Popeye's – Cameron, NC

Permit/Review response

Client #C22-129

Harnett County Development Services

Drawing Title: LIFE SAFETY & EXITING PLAN

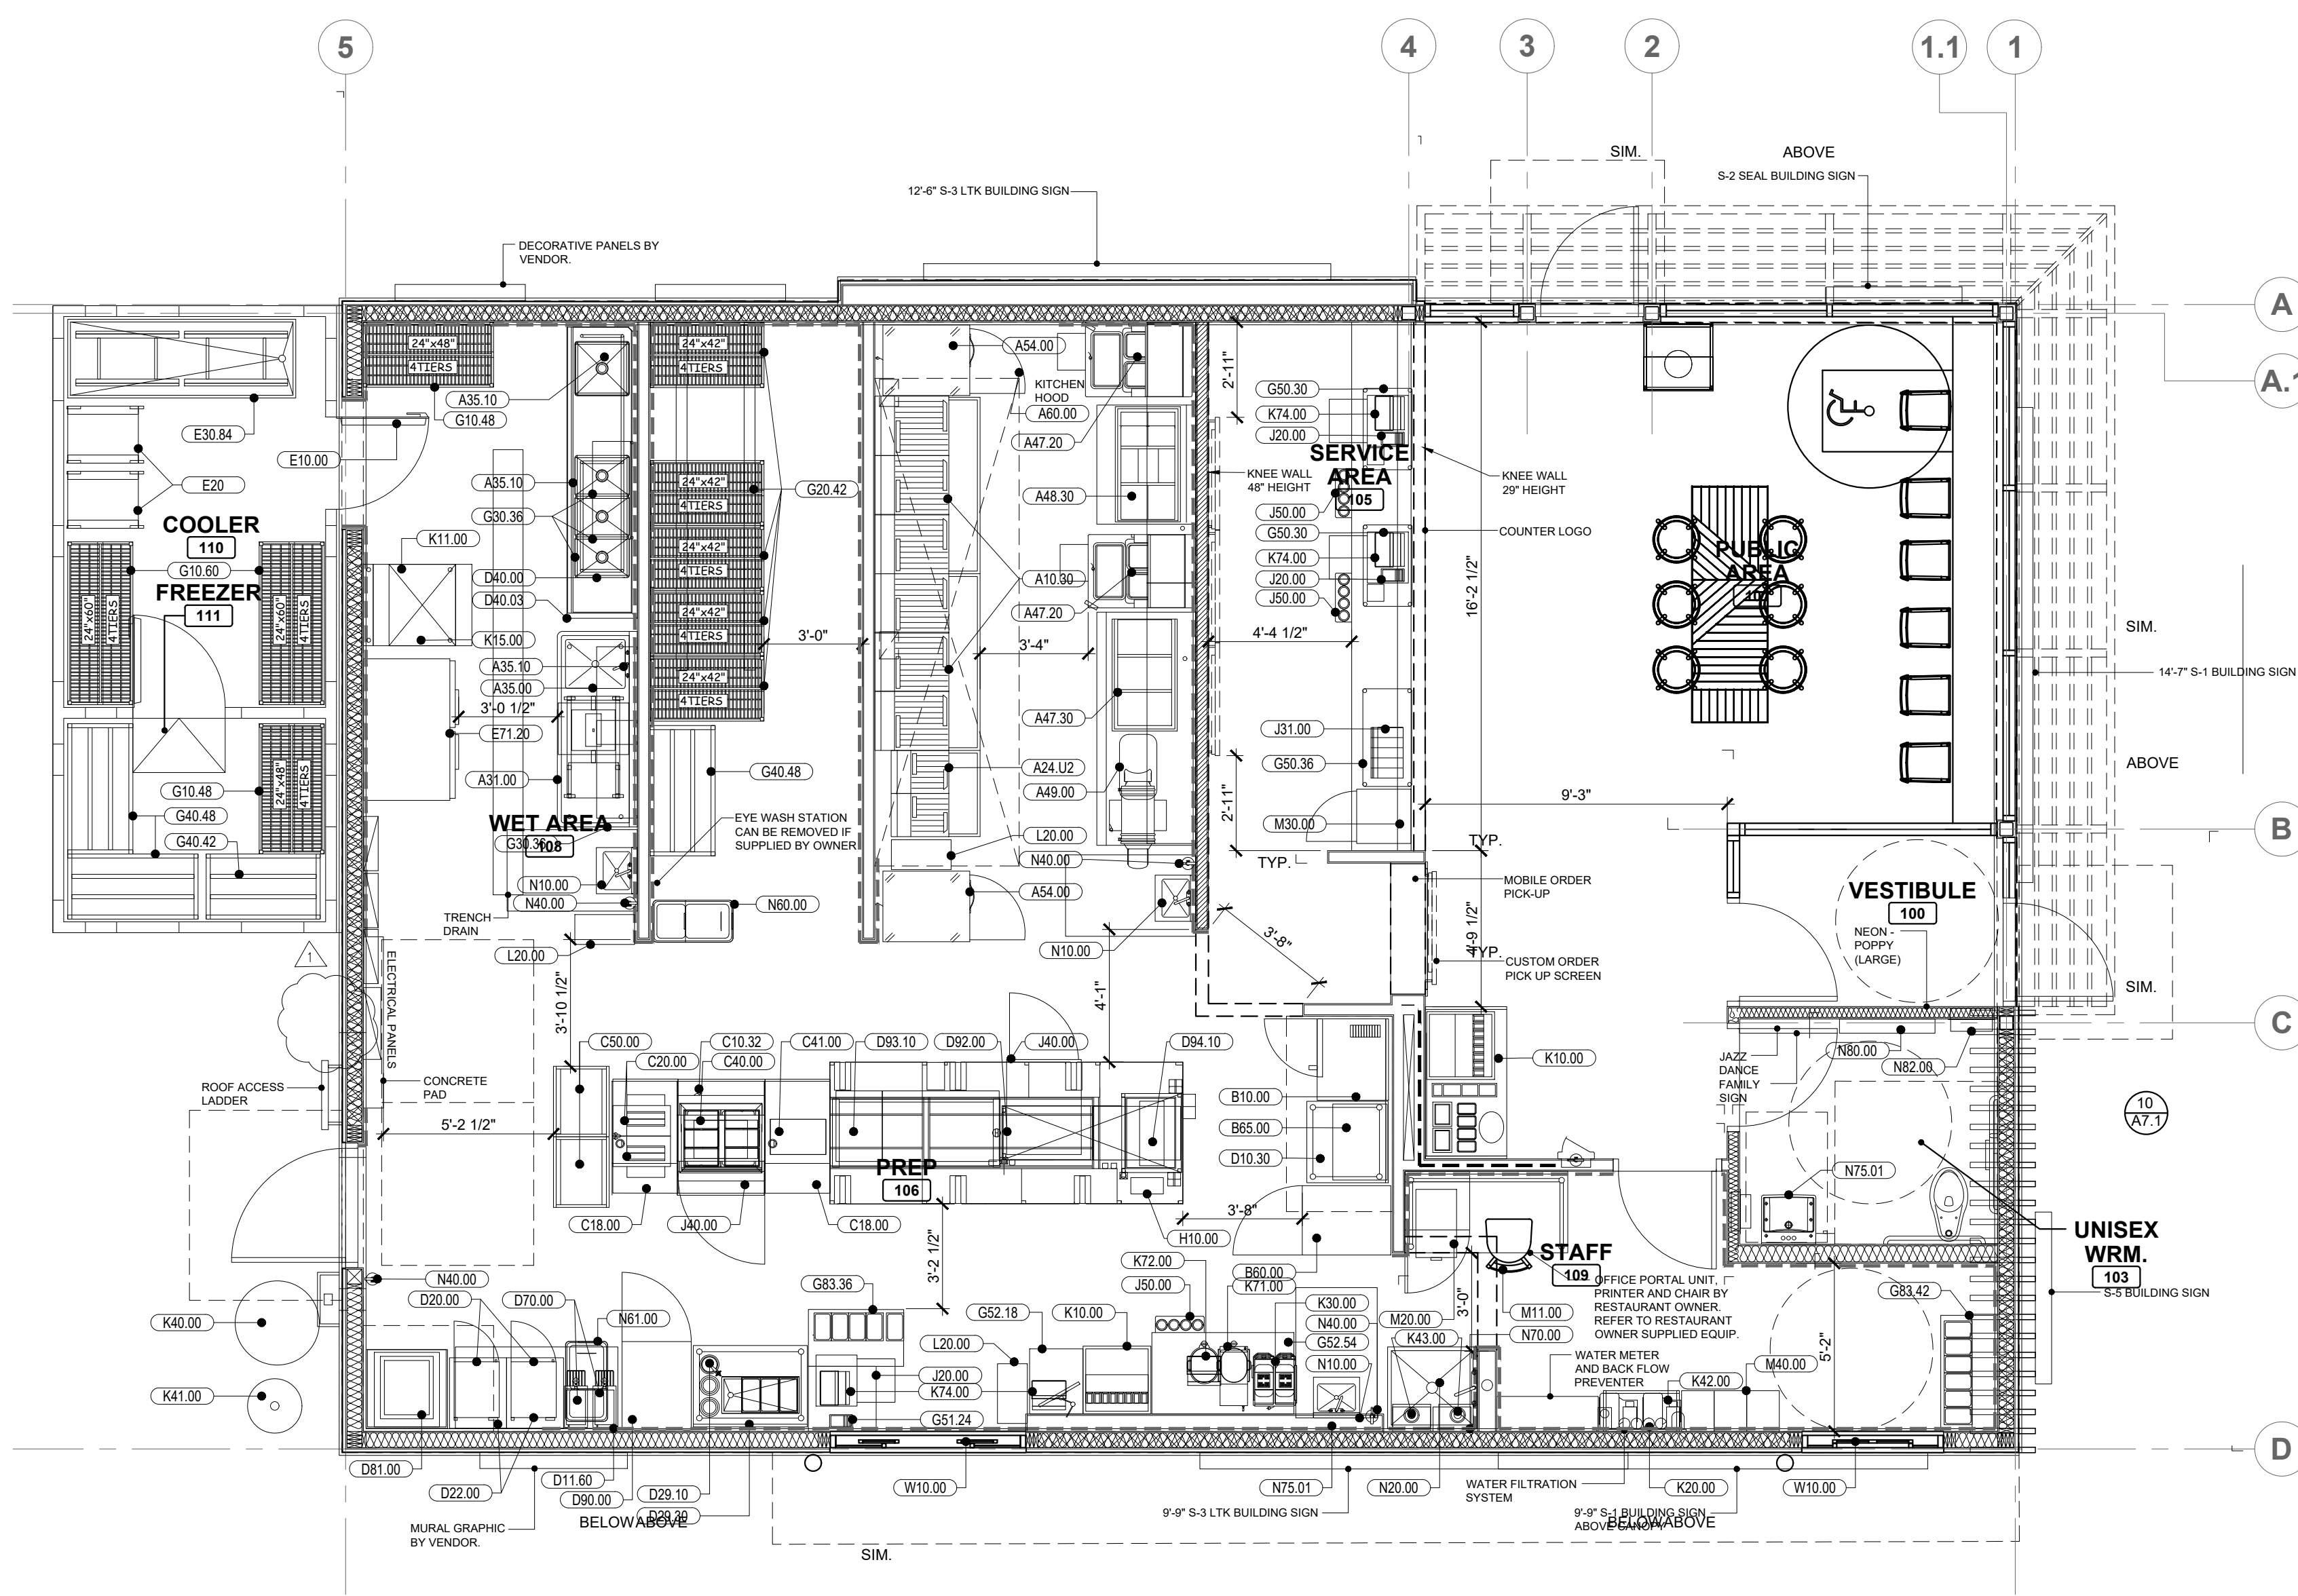
No life safety plan was submitted.

Need a life safety plan.

Response: Sheet AS2.4 was added

Response: Sheet AS2.4 was added
